From: Bernie Harverson <[REDACTED]>
Sent: 31 May 2014 09:54
To: 'Greg Roberts'; 'Ross G'
Cc: Joe Russell-Wells; Richard Martin; Sue Howell; Neil Crowther
Subject: RE: Goodacres, Barnham

From: Bernie Harverson [REDACTED]
Sent: 28 May 2014 20:56
To: 'Ross G'; Greg Roberts
Cc: 'Neil Crowther'; 'Joe Russell-Wells'; 'Richard Martin'; 'Sue Howell'
Subject: Goodacres, Barnham

From: Sue Howell
Sent: 15 May 2014 15:55
To: Neil Crowther; Bernie Harverson (bernie.harverson@virgin.net)
Cc: Joe Russell-Wells
Subject: RE: BN/13/14 Landscaping

From: Alison Meeus <alison.meeus@westsussex.gov.uk>
Sent: 27 May 2014 11:00
To: Neil Crowther
Cc: Greg Roberts [REDACTED]
Subject: FW: BN/13/14

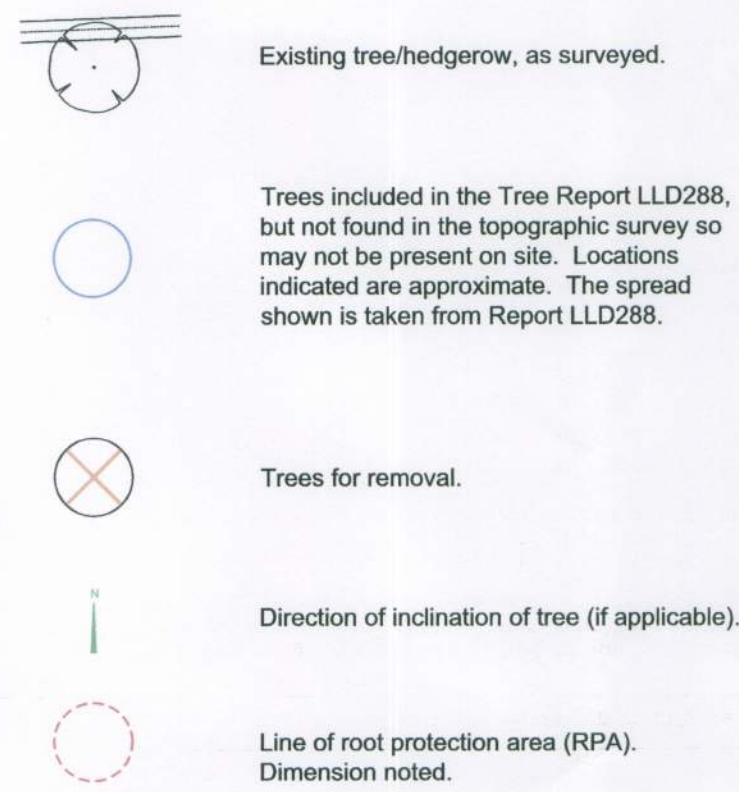
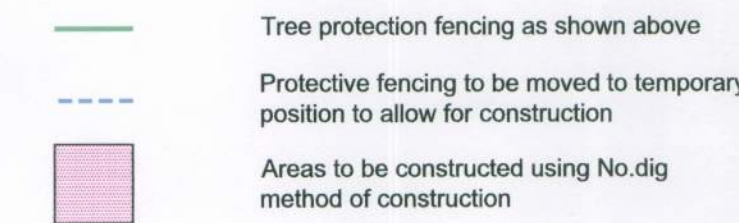
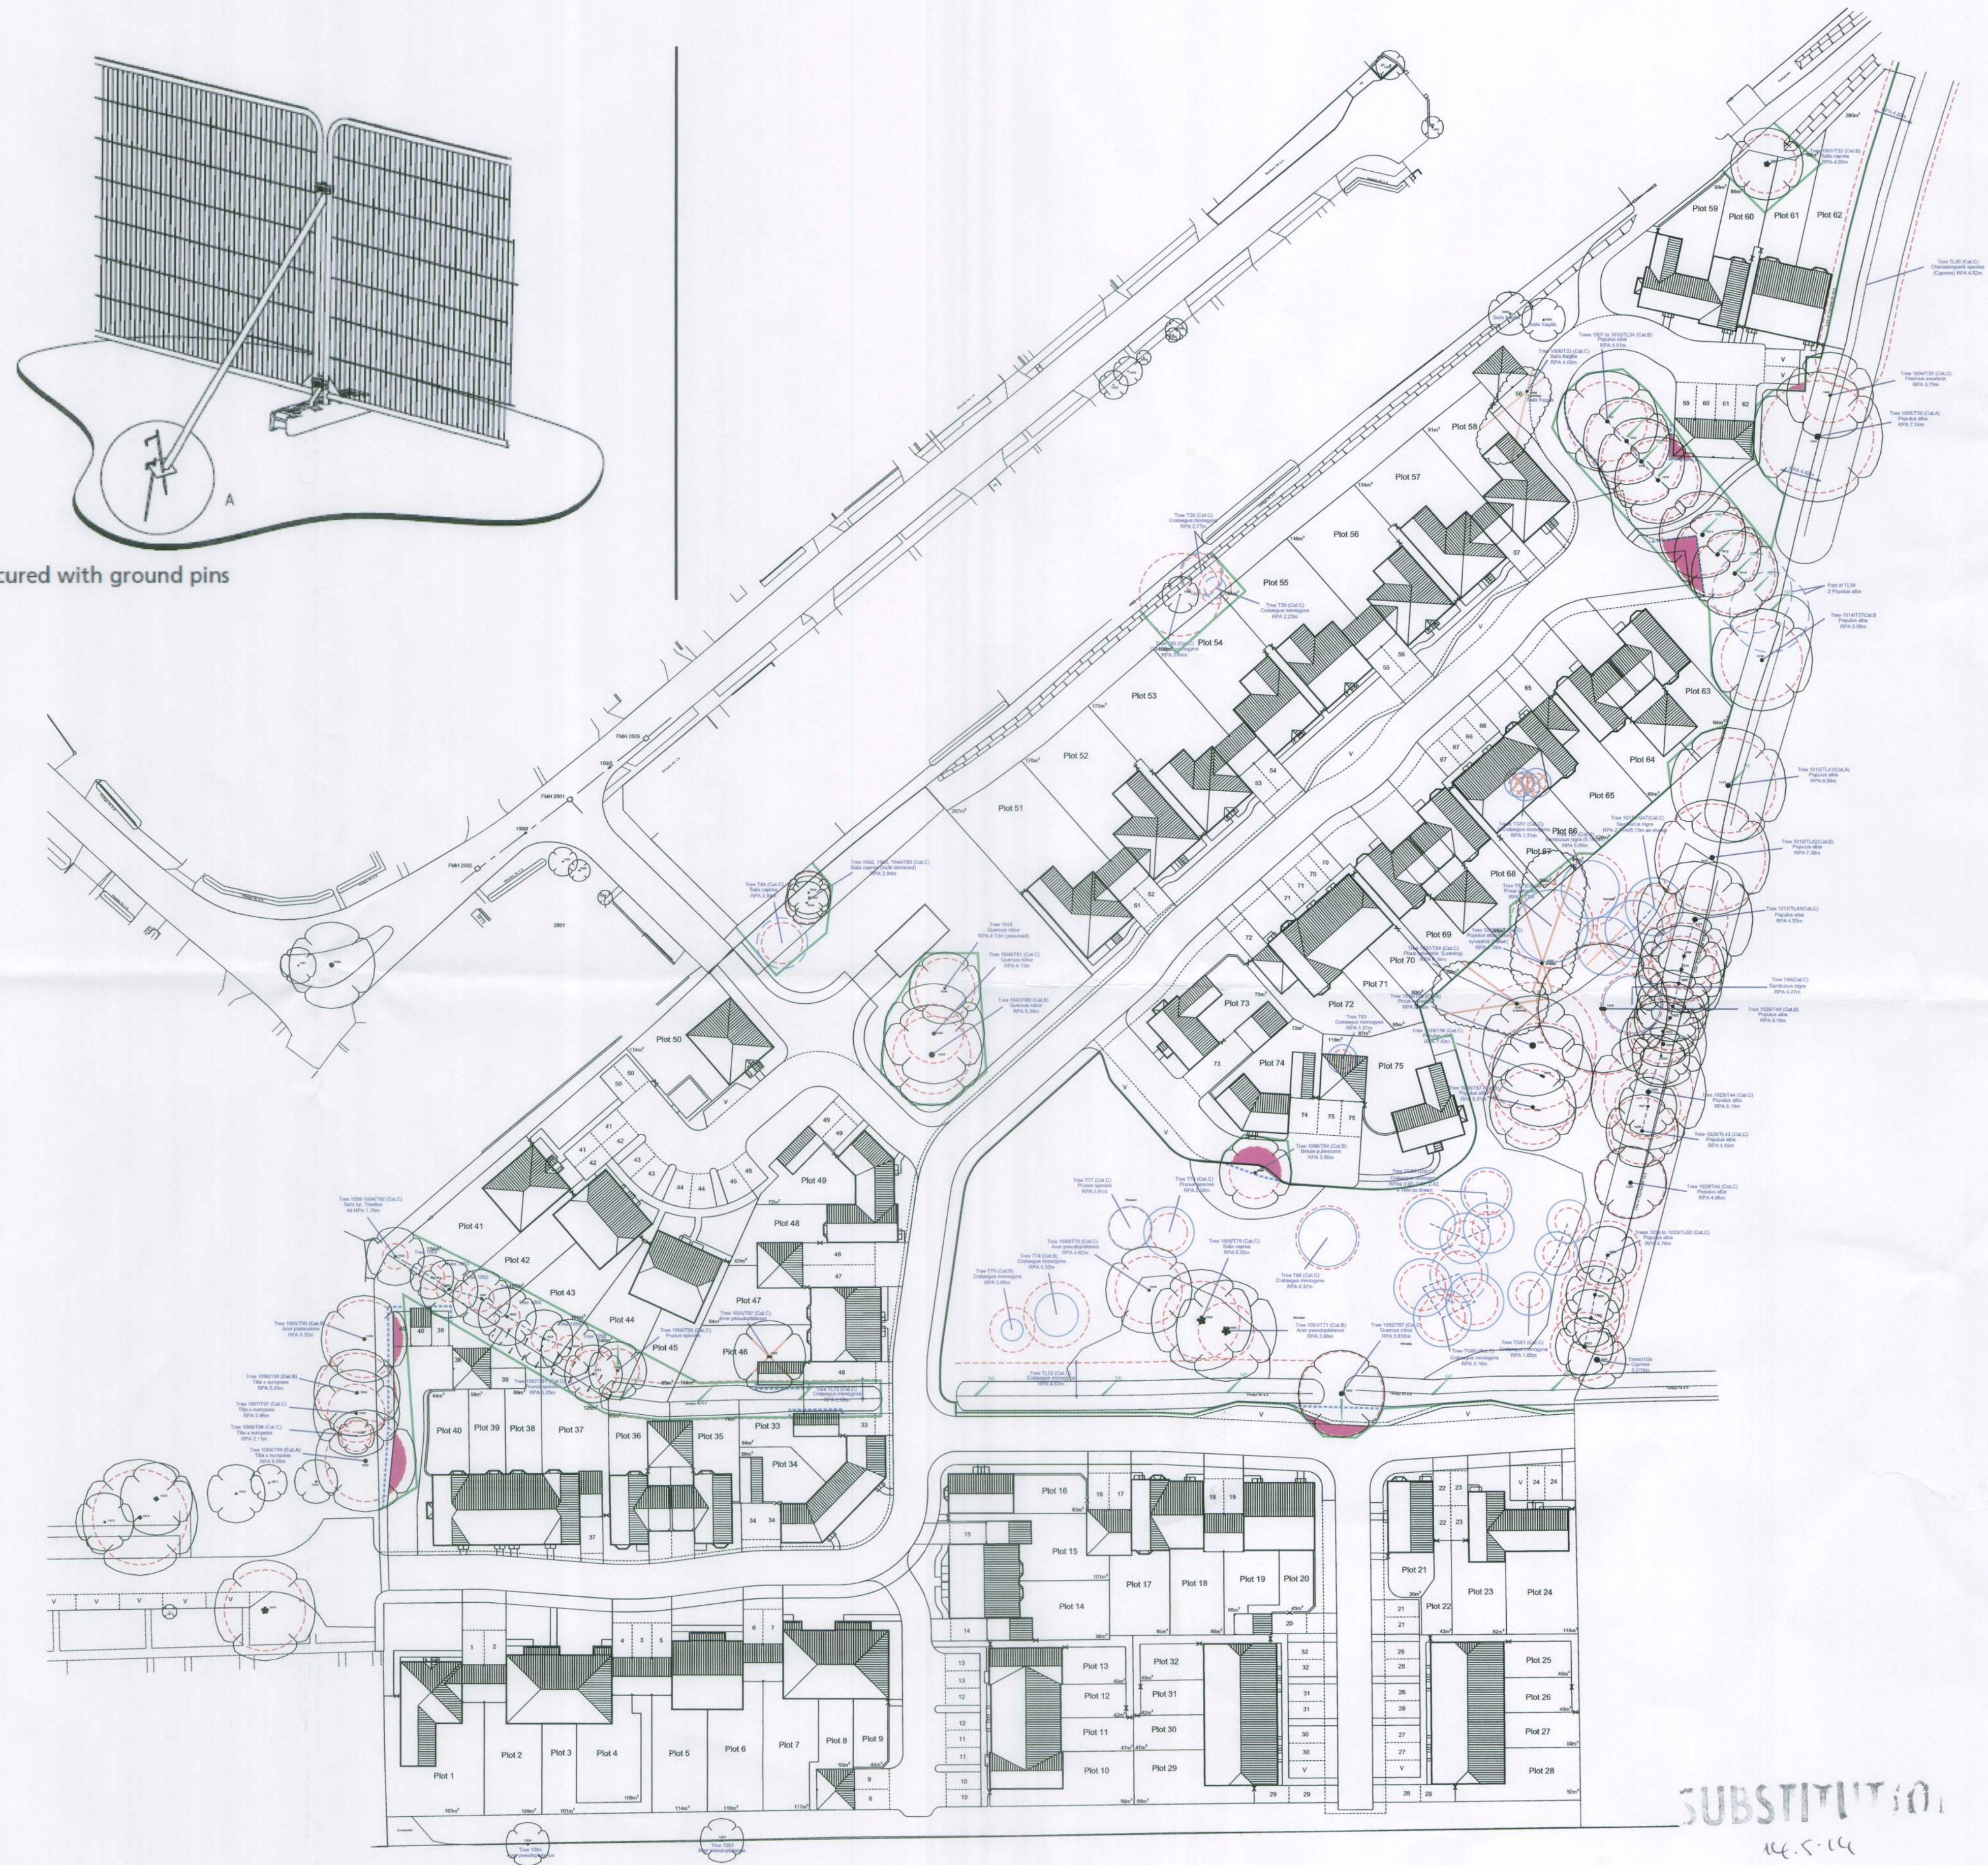
- **Pines 1036 & 1037** – both have collapsed and been uprooted but are shown to be retained – I would prefer to see these removed and quality Heavy Nursery Stock replacement plantings undertaken in this area.

- Whilst on site I pointed out that **the Willow trees 1058 to 1064** have all been felled (by person or persons unknown) and this will need to be reflected in the final set of drawings that are to be submitted.

1. A revamped and revised **Planning Layout Drawing/Tree Protection Plan** to show the modifications to layout and protective fencing (including Figure 2 drawing from BS5837 NOT Figure 3 as previously submitted please).
2. IF you are intending to retain the Grey Poplar trees 1007 to 1010 then we will need a **mini Method Statement** to be submitted detailing the tree works specification and also the details of arboricultural expert monitored 'hand digging' and root severance works.
3. A revamped **Landscape Master Plan** will need to be submitted showing the full extent of tree removals and proposals/specification for new quality tree planting works.

We have taken the view to remove the poplars and replace them with some extra heavy standard oaks as you have suggested and the tree protection plan has been updated to show the tree protection fencing as figure 2 from the British Standard.

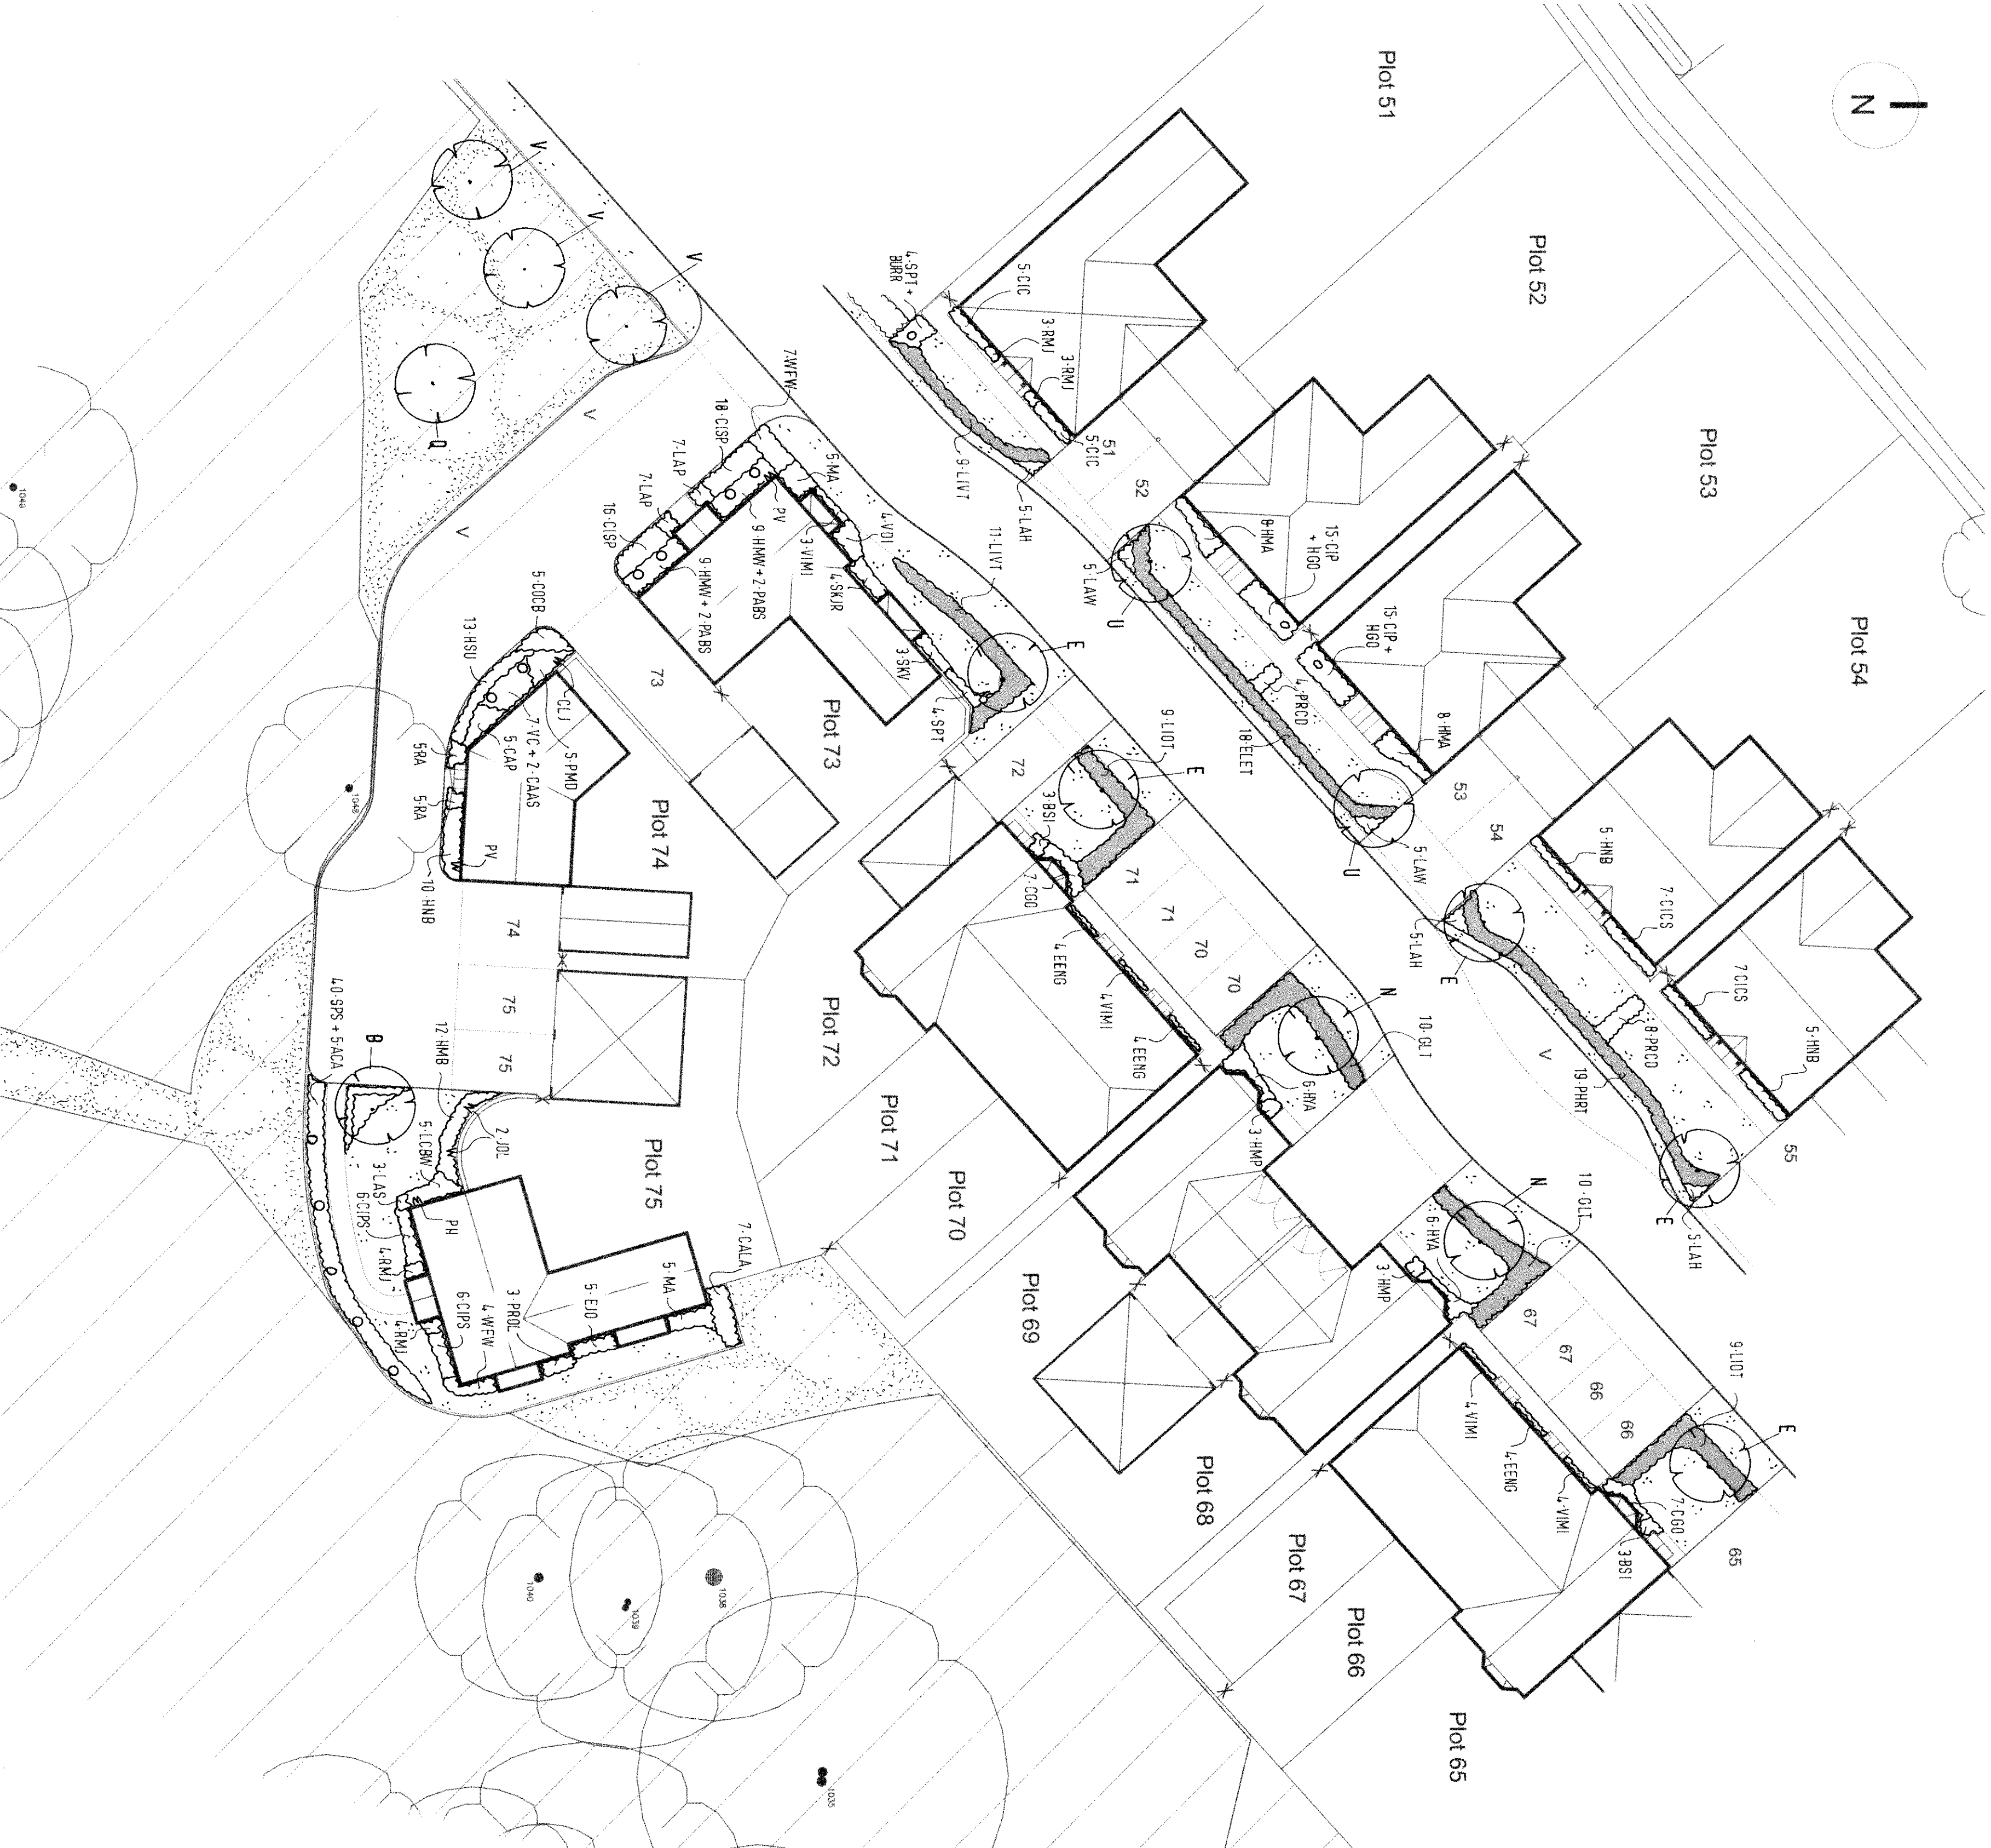
I have reviewed your current set of plans and I think we now have a fixed layout that meets my satisfaction on arb issues - but I now have reservations about the density of new planting shown at the top end of the site as Oak will become a large tree and needs room to develop a full crown (and they will be due south of the plots at the top of the site) and I think less trees planted here and more shown distributed around the site will be the best outcome. I am next in my office to be able to scan and email my suggested revisions this coming Tuesday so will issue then - hopefully this will just involve a tweak to the landscape drawings and then we will have a viable and satisfactory scheme.
